Our ref: DOC22/256365-2
Your ref: SSD 12469087

Subject: Gunlake Quarry Continuation Project Response to Submissions

Enclosure: Attachment 1 – Outstanding biodiversity issues for the Gunlake Quarry Continuation Project

Gunlake Quarry Continuation Project
Groundwater assessment
Figure 6.4

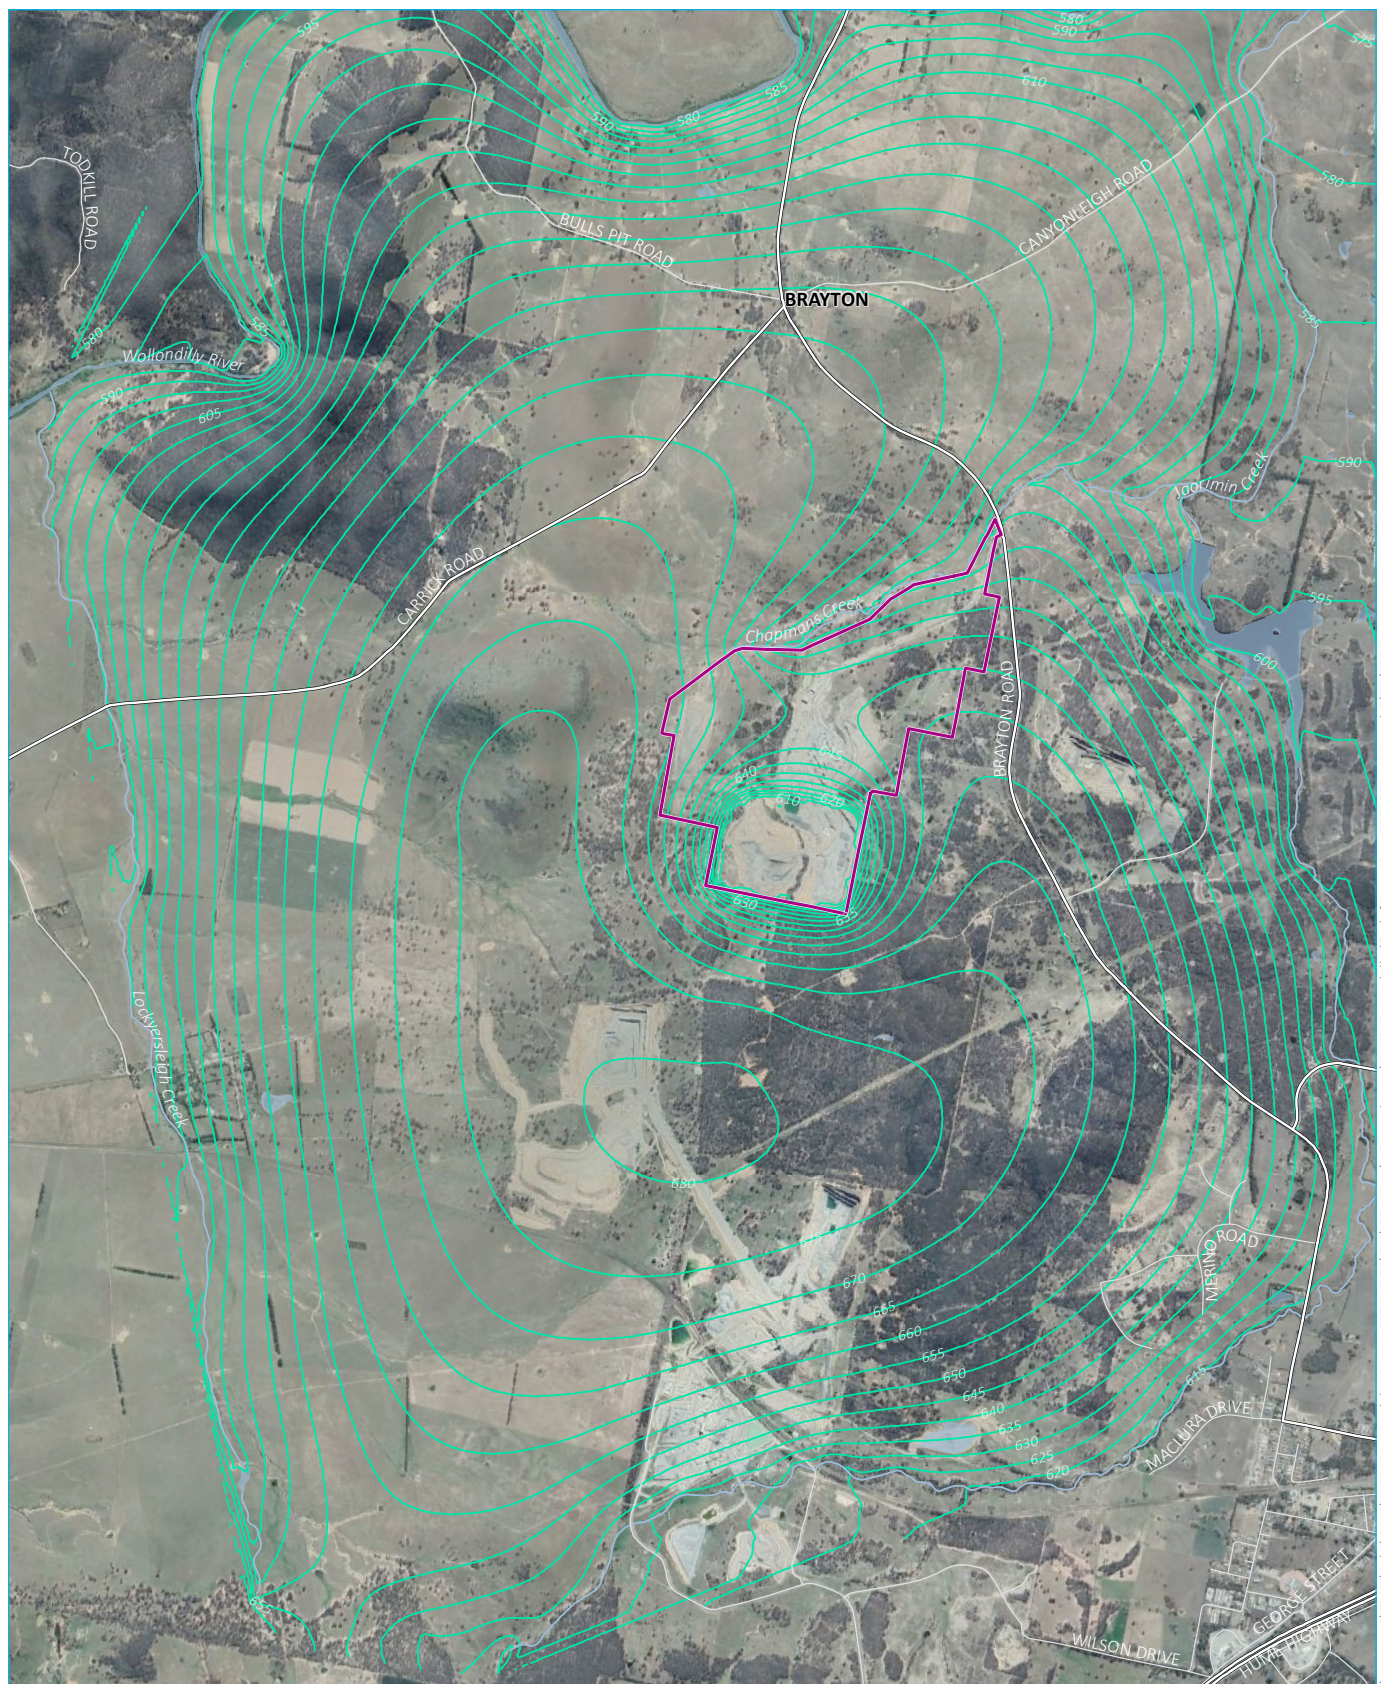
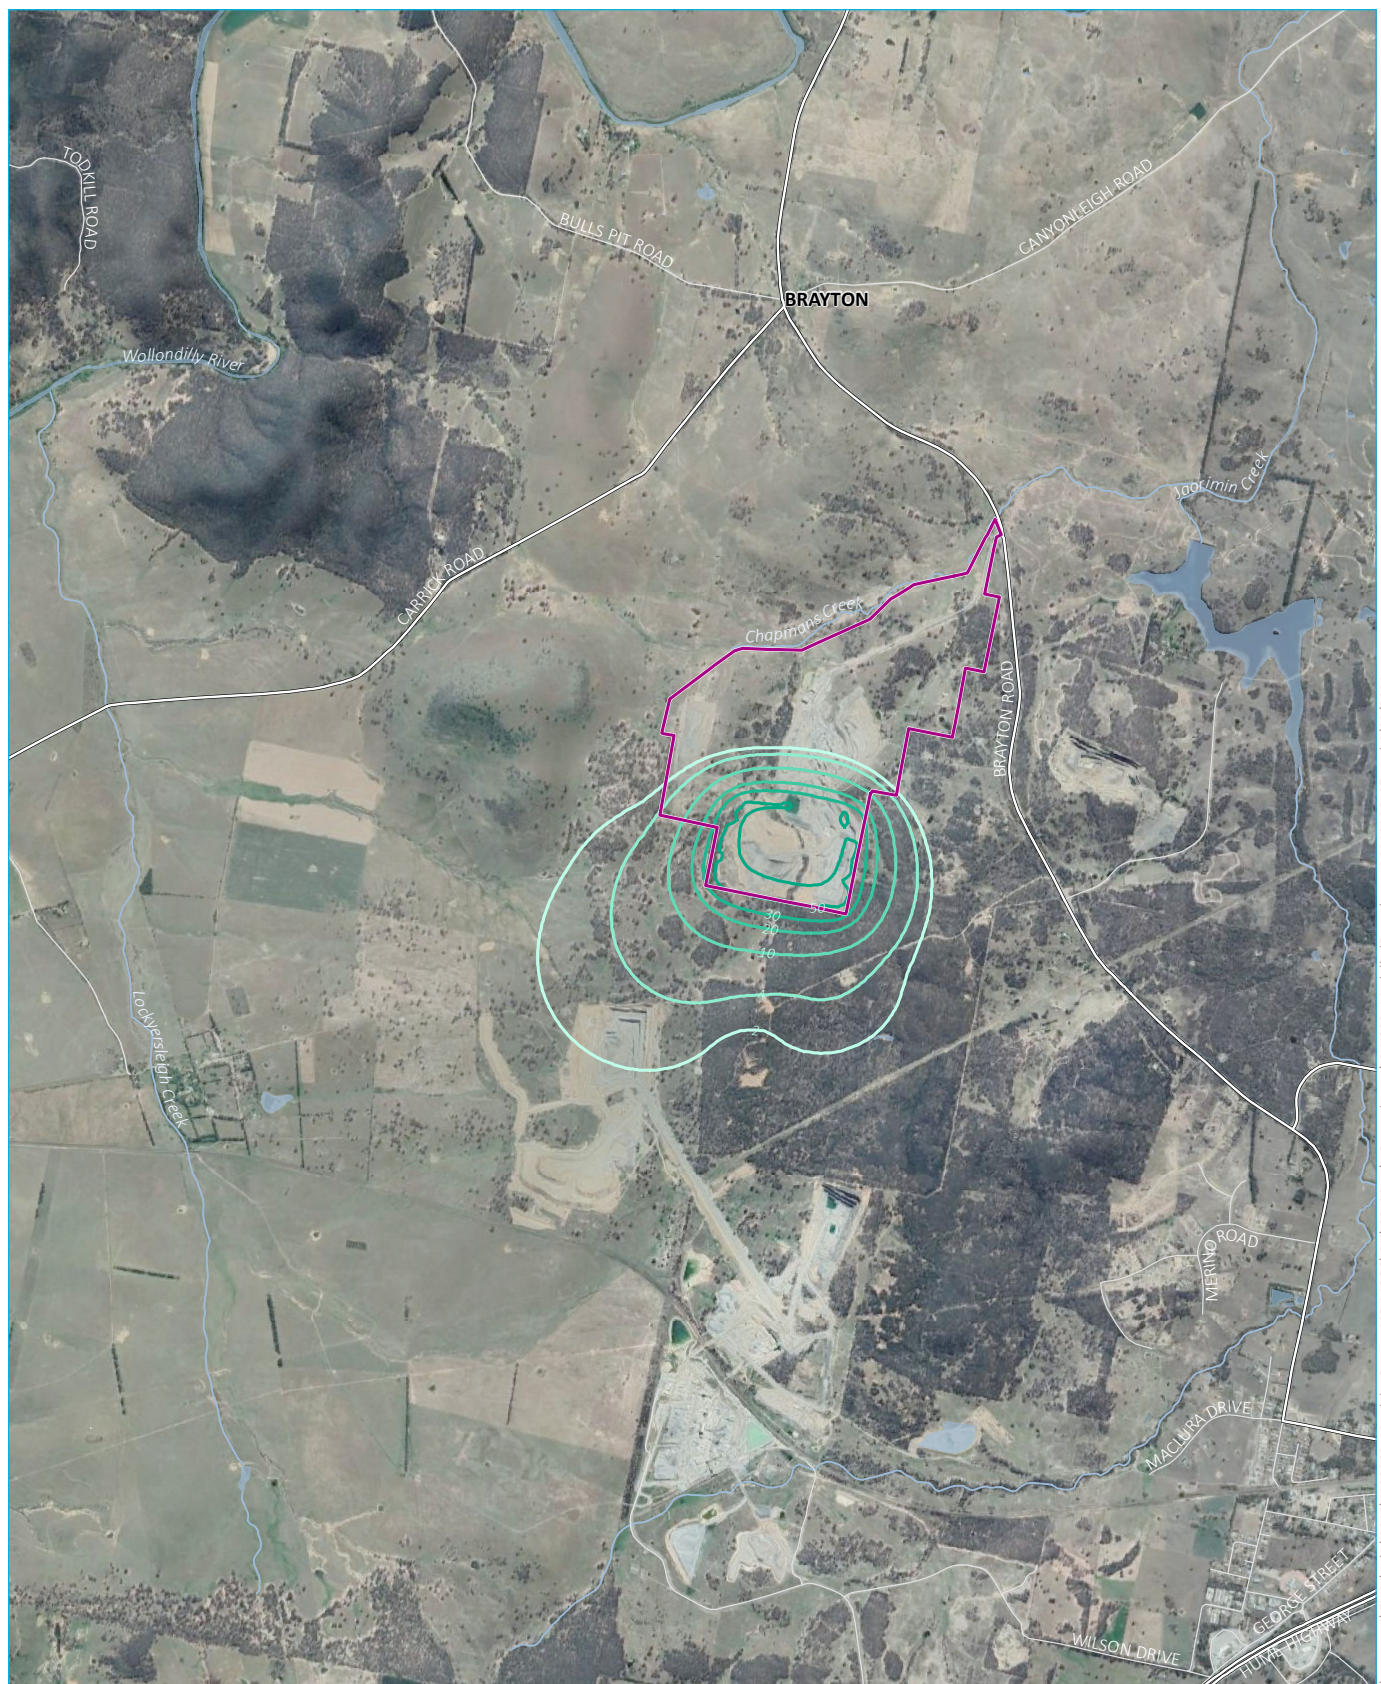
- The RTS has not provided explanation for why the predicted groundwater level is 30m different to that of the Holcim model for the same area. This is a discrepancy equivalent to a seven-storey building. Both the Holcim and the Gunlake models cannot be correct.

- It is still unclear why the groundwater model only shows drawdown occurring to the south of the pit.

- **Recommendation:** We agree with DPE Water's recommendation that the Applicant should improve the robustness of the impact predictions with a numerical groundwater flow model that is -

- calibrated and validated.
 - consistent with the Australian Groundwater Modelling Guidelines.
 - independently reviewed.
 - Due to the potential risks to an existing biodiversity offset site and a critically endangered ecological community, the independently reviewed groundwater model should be *prior to consent*.
